# CITY OF ALBUQUERQUE

January 7, 2014

RE: **Alamosa Neighborhood – Habitat for Humanity** File # **K11/D083**  
Townsend Ave SW; Lots 31 – 37, Daniel G. Herrera's Subdivision  
**Grading & Drainage Plan** for Grading /Building Permit **PE Stamp: 12/27/13**

| CITY OF ALBUQUERQUE<br>PUBLIC WORKS DEPARTMENT<br>ENGINEERING DEVELOPMENT GROUP |  | PLAT                    |  |

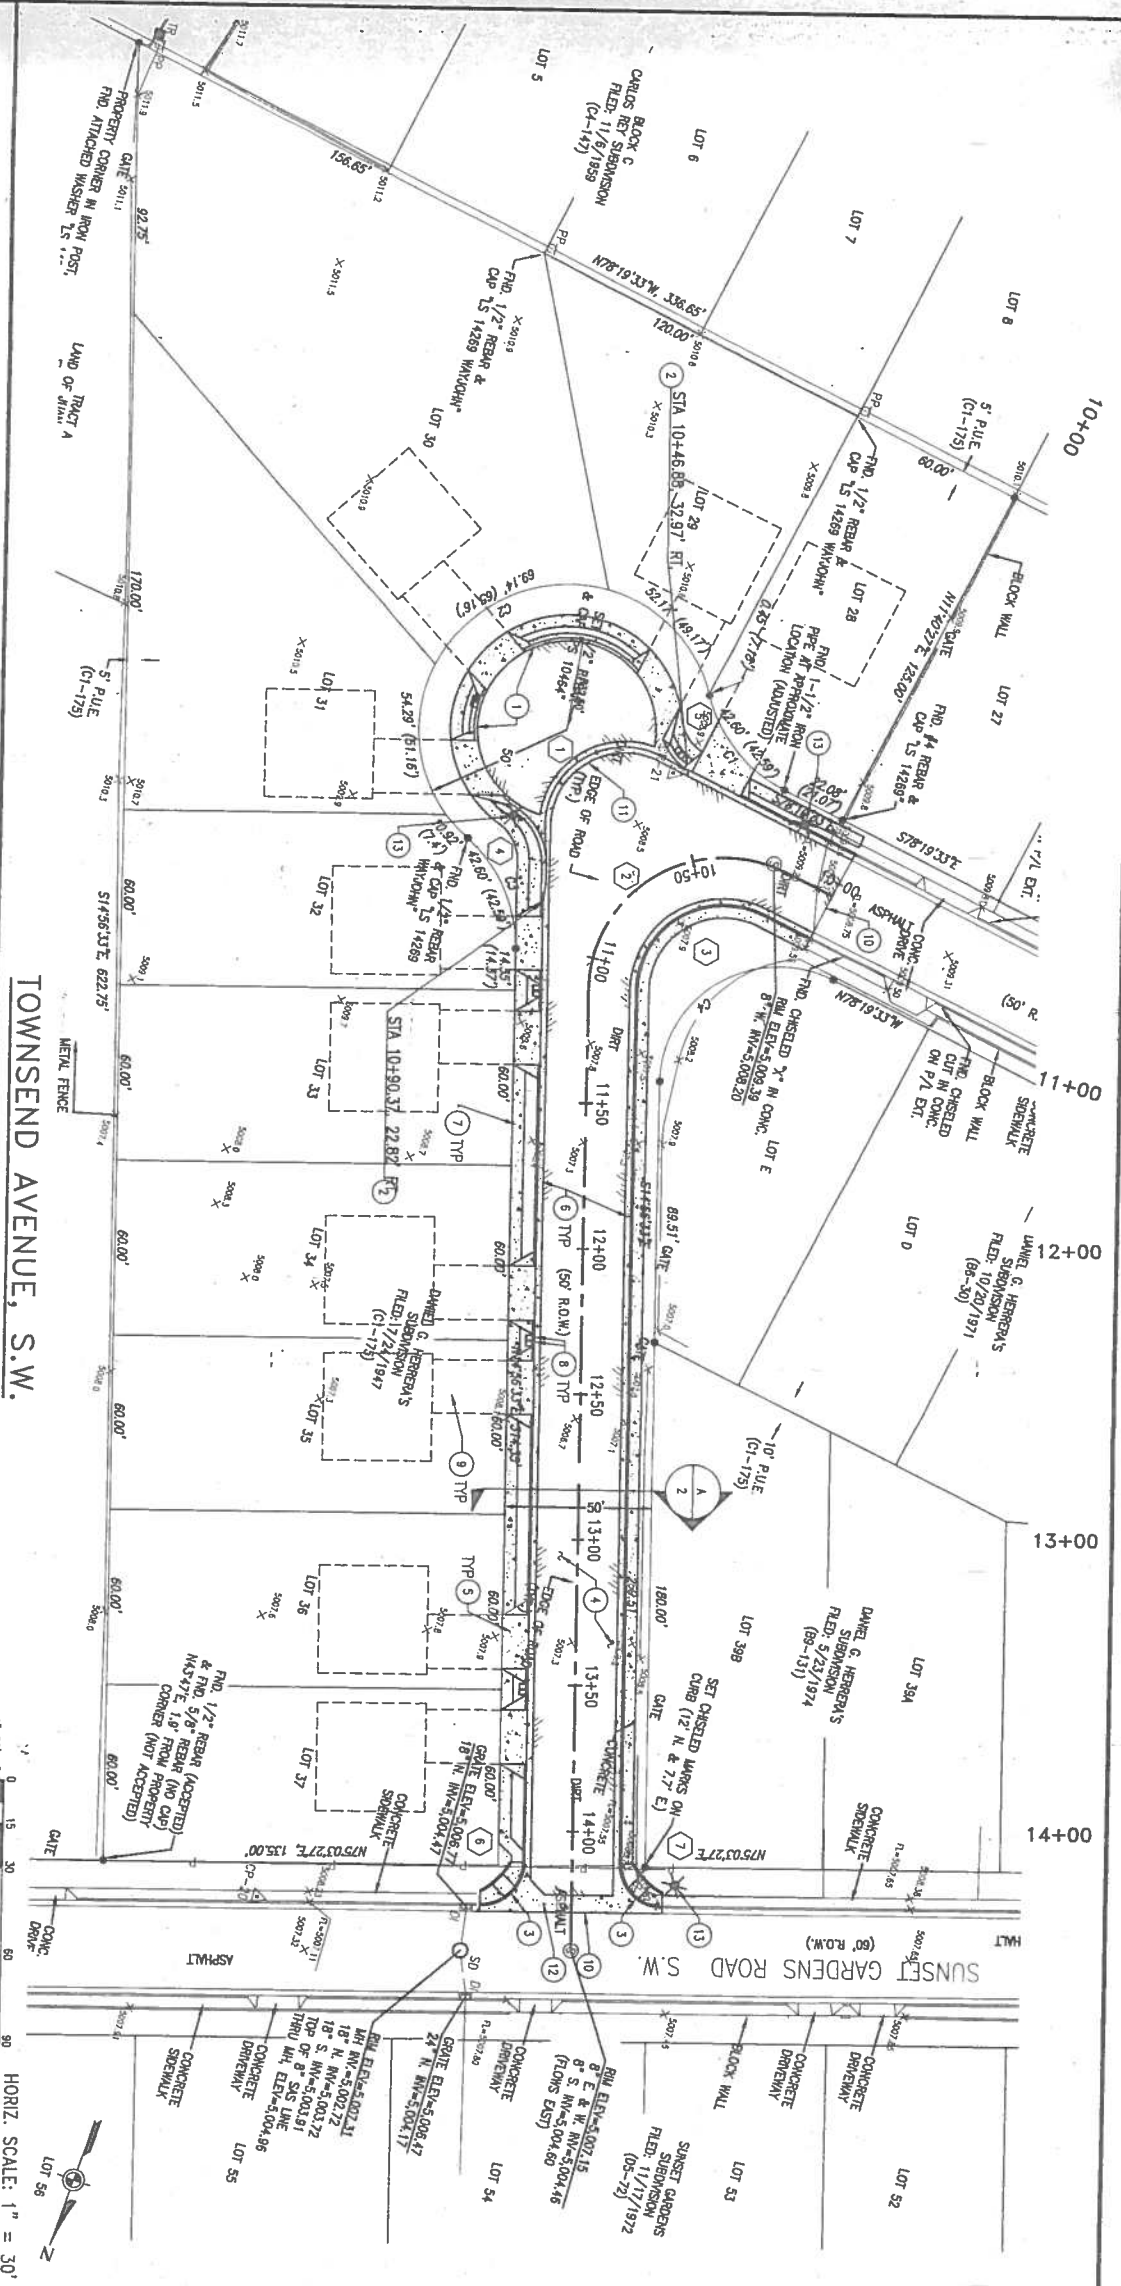
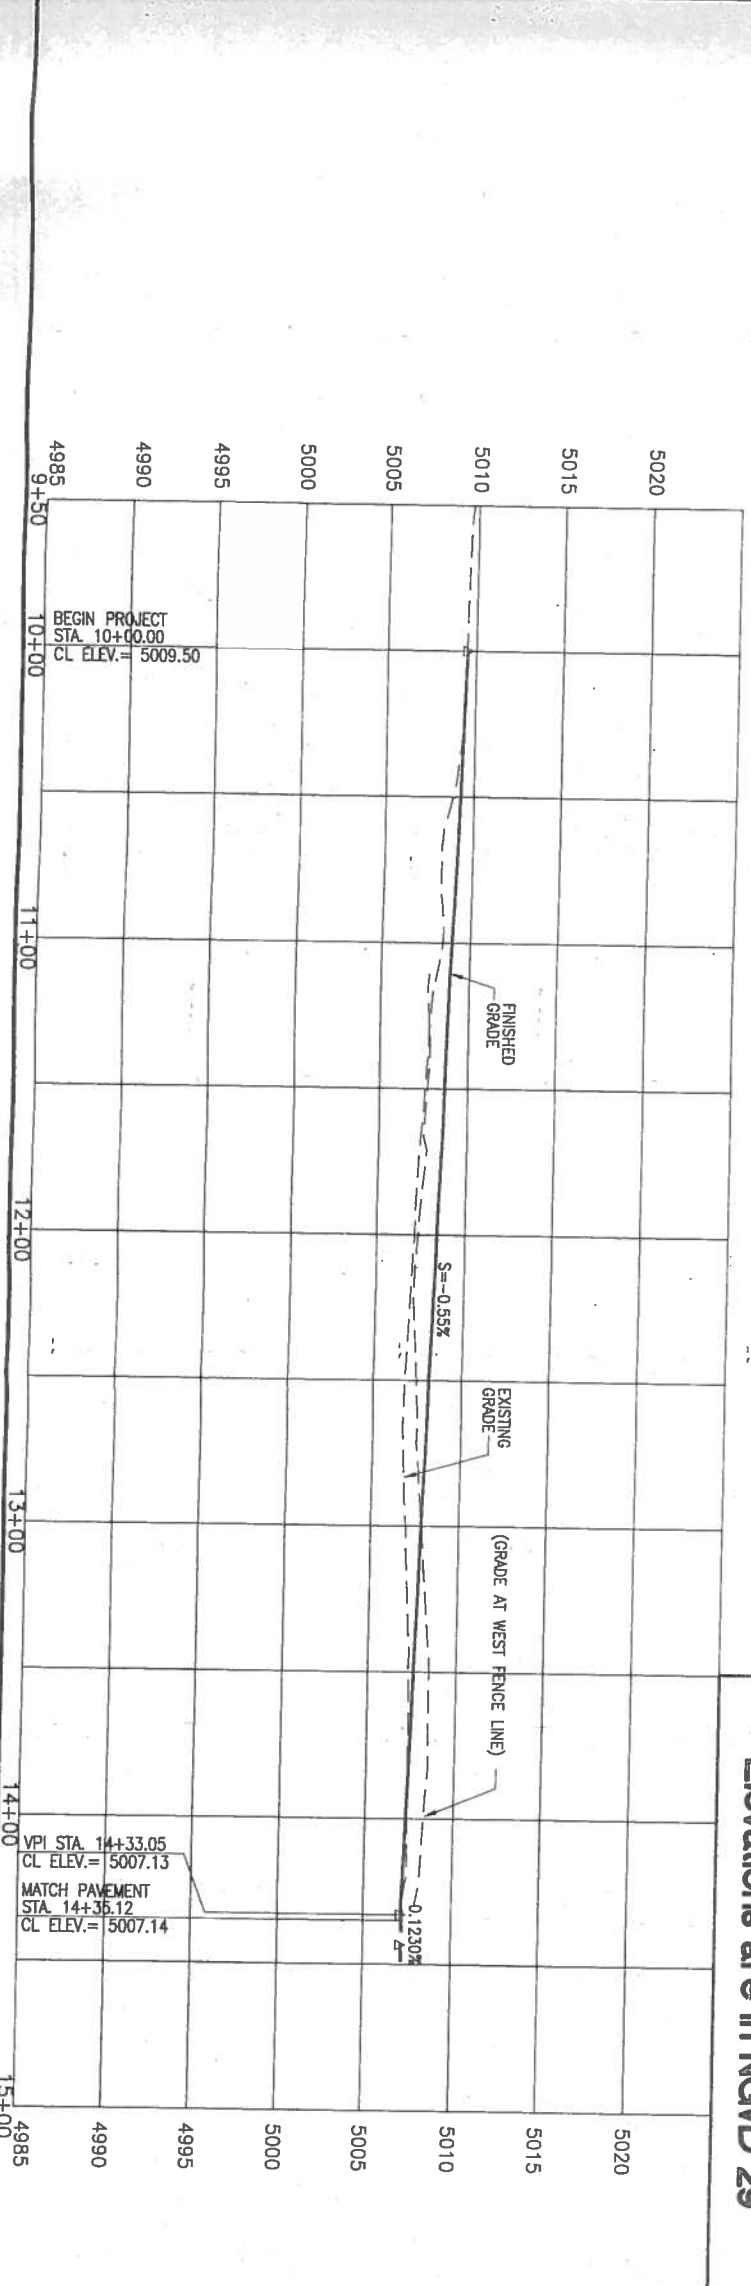
1. Provide spot elevations for construction of the Front Yard Ponds along Townsend, including bottom elevations and overflow grades (shown on Tables on Sheet 7).
2. Verify the survey grades on sheet 3, specifically the 3-foot grade difference in  $\pm 20$  feet at the south end of the knuckle on Townsend.
3. Provide the source reference for the survey used on this plan (Harris Survey?).
